Application No: LU/260/21/HH
Site Address: 49 Northway Road Littlehampton BN17 7JX
Description of works: Erection of first floor rear extension

Thank you for your internet representation made on 7th October 2021 which has been recorded as an objection with the comments as follows:

DRWG TITLE: **Proposed Elevations**
DRWG No: **1046_301**
REV: **B**

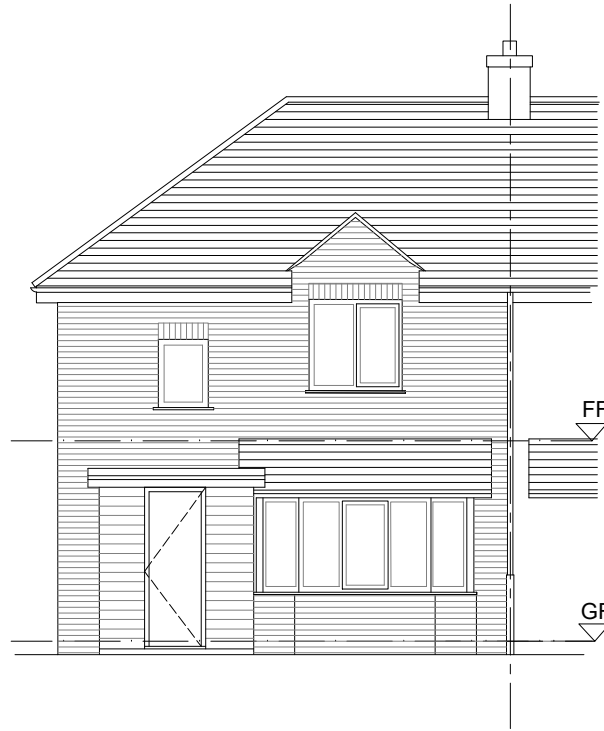
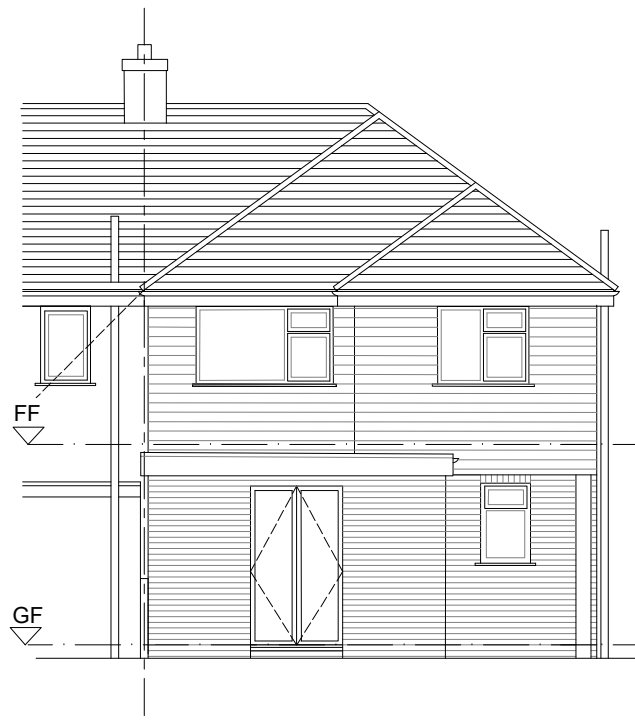
As per my previous comments on the last planning submission, I feel that this extension will be overbearing to my property, the view from bedrooms will be affected and the natural light in my garden will reduce greatly! As said before their bottom extension already blocks my sunlight from 6pm in the summer leaving my garden in shade and even earlier around 2-3pm in the winter sun! As per pictures submitted before. The cladding effect design is also not in line with the roads properties.
